Re: SPARE TIME PORTLAND CITY &
SPORTS GRILLE

Entire Building Life Safety Layout

Revision of plans for State Fire Marshal's Comments dated 7-21-16
(attached)

Plan Review Summary

OVERALL BUILDING DIAGRAM

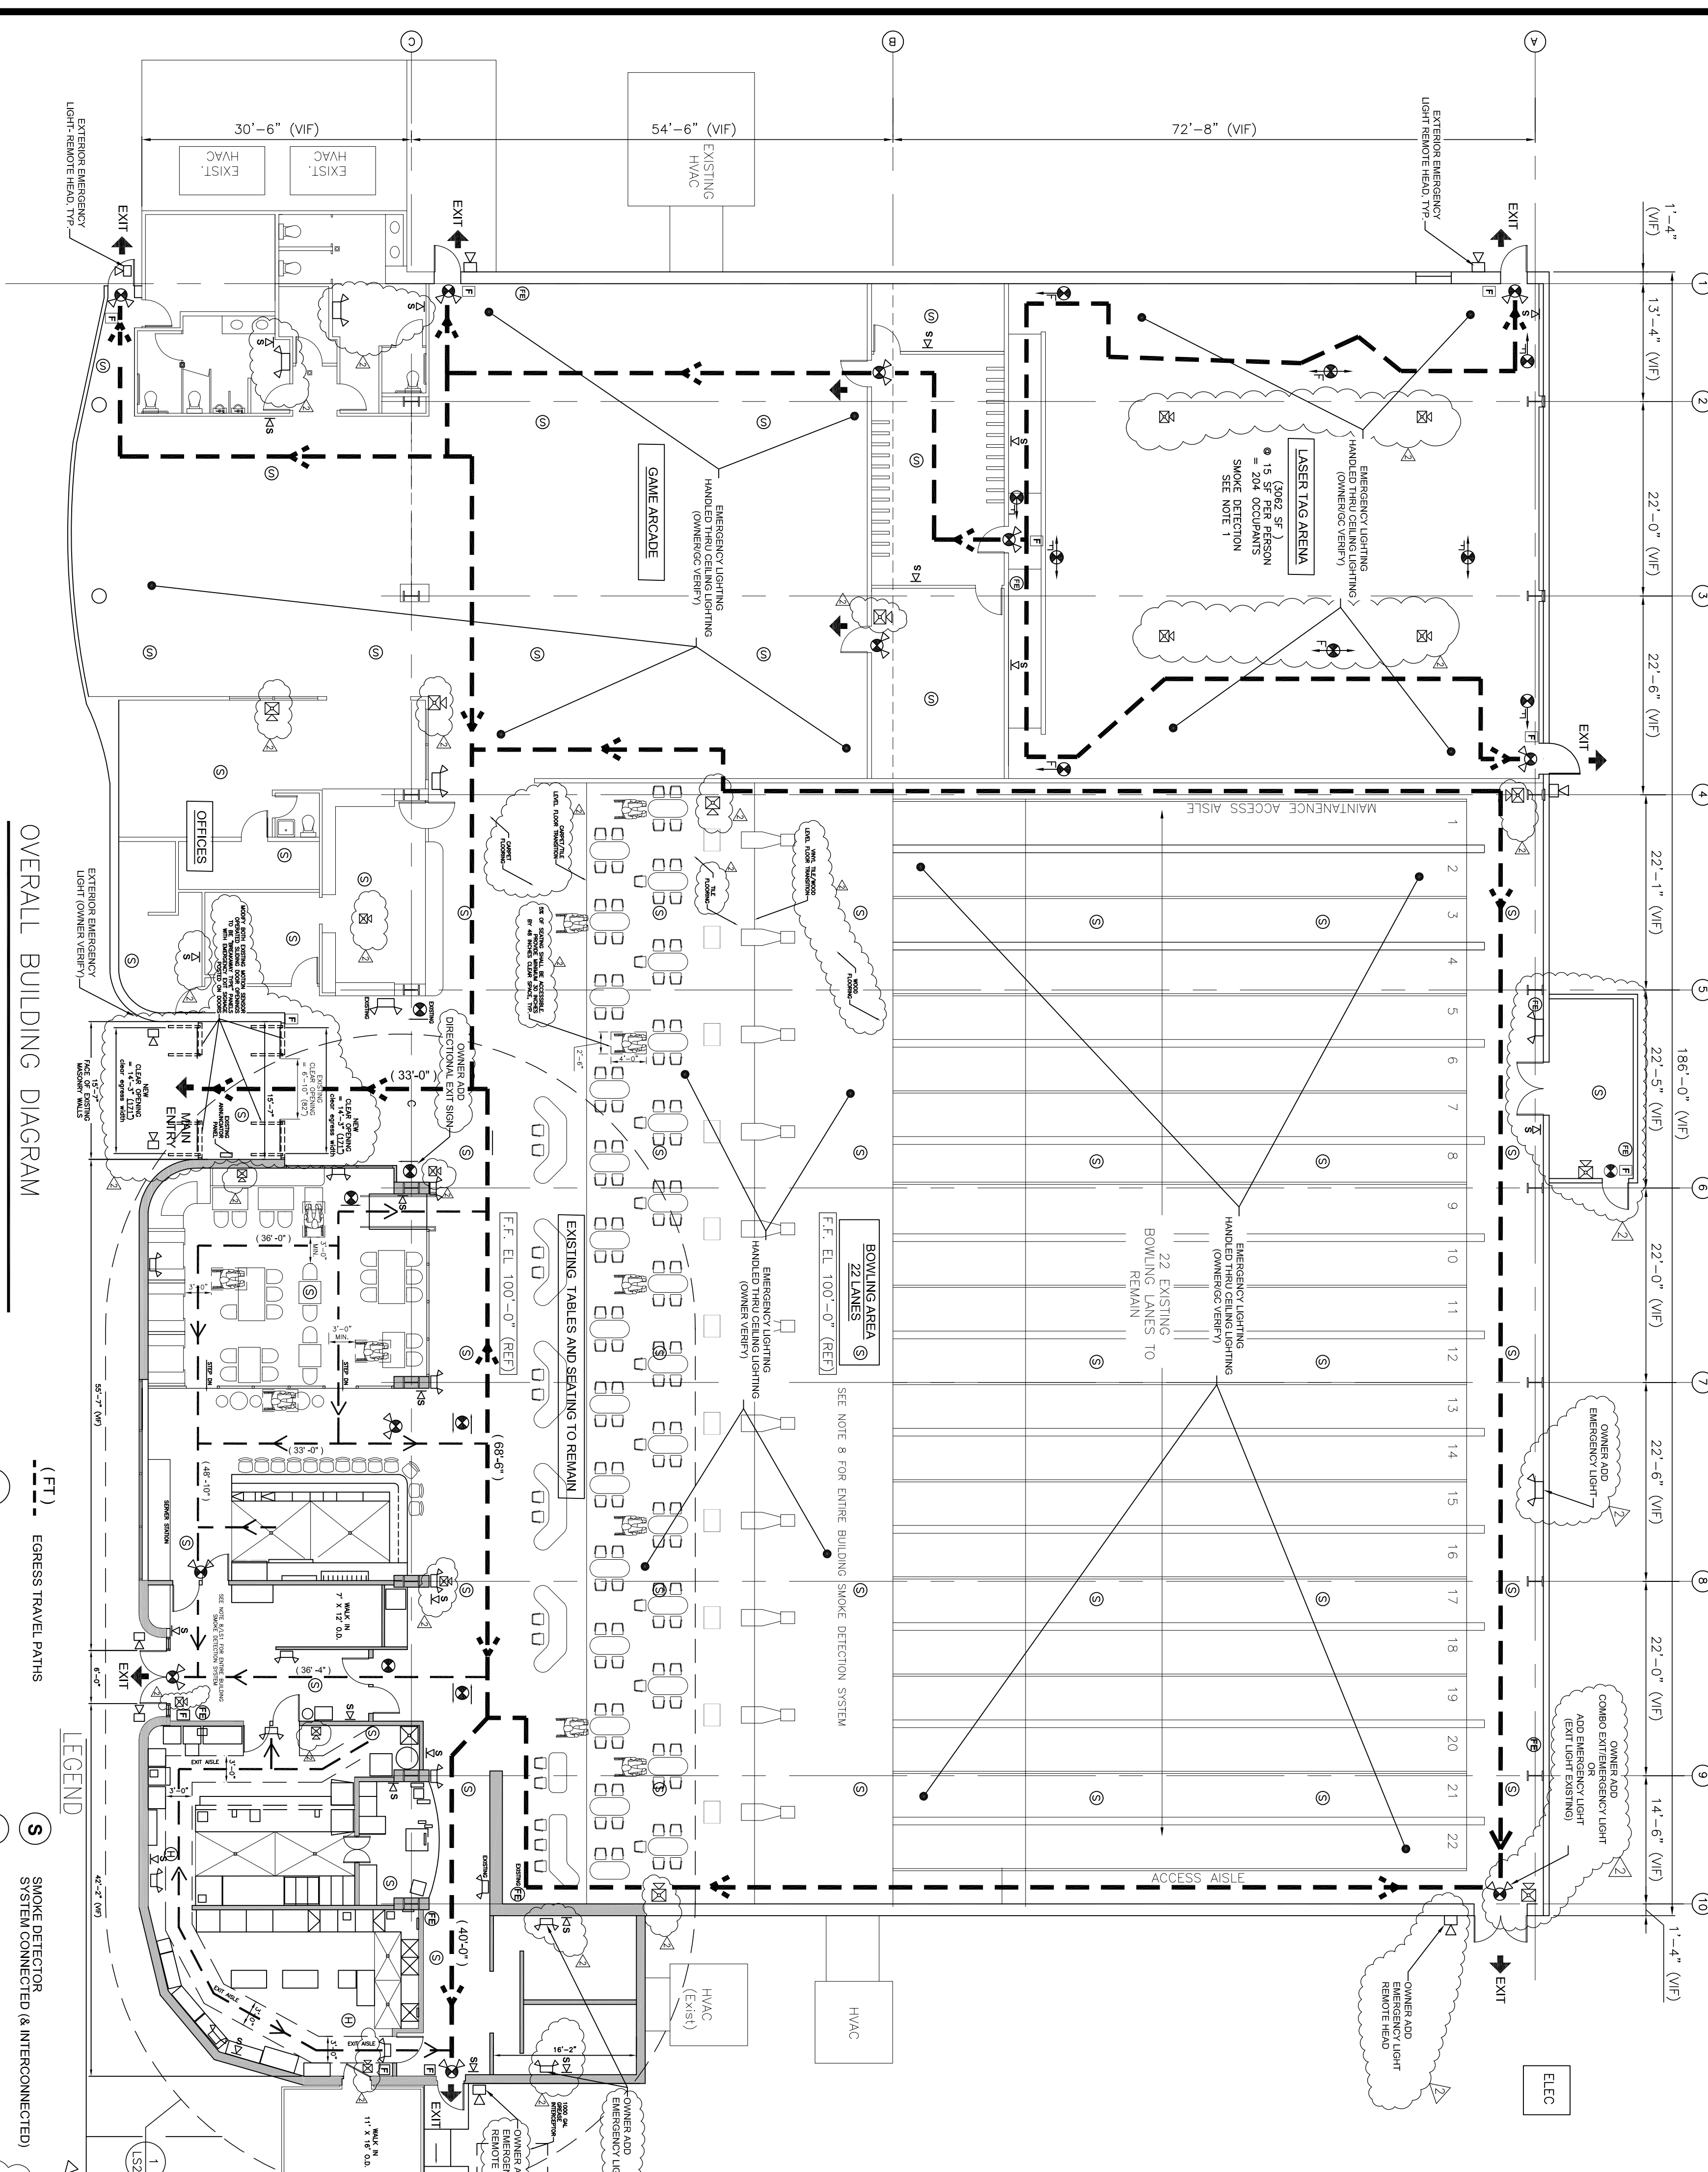
- 1) Please provide locations of all exit signage
- 2) The alarm system is required to have audio notification as well as visual. Please provide locations of both types of notification
- 3) Where will the constantly attended receiving station be located or will an automatically transmitting evacuation be used?
- 4) Is there smoke or heat detection in the laser tag area?
- 5) The main entrance doors appear to be too narrow. They are required to accommodate $\frac{1}{2}$ of the occupant load or 98.8 clear inches.
- 6) Please provide emergency lighting in the restrooms
- 7) 5% of the fixed seating is required to be ADA accessible (booths & bar)
- 8) Will ADA accessibility be provided at the lanes? (seating both levels as well as the lanes)
- 9) Will the kitchen hood be included on this permit or permitted separately?

1. All illuminated exit signage has been shown on the attached plans.
2. Locations of Speaker/Strobes indicated on REV 2 plans (attached)
3. The Fire Alarm System is monitored at a remote, constantly attended station by *Tyco Simplex Grinnell* staff. The emergency voice annunciation is a pre-recorded voice message integrated with the fire alarm system. See notes 1 & 2 on drawing LS1.

4. Room Smoke detectors were not installed in the Laser Tag arena. City Fire Dept. directed contractor to use "quick response" sprinkler heads in lieu of room smoke detectors and also added heat detectors in air handling ductwork. Refer to note 1 on drawing LS1.
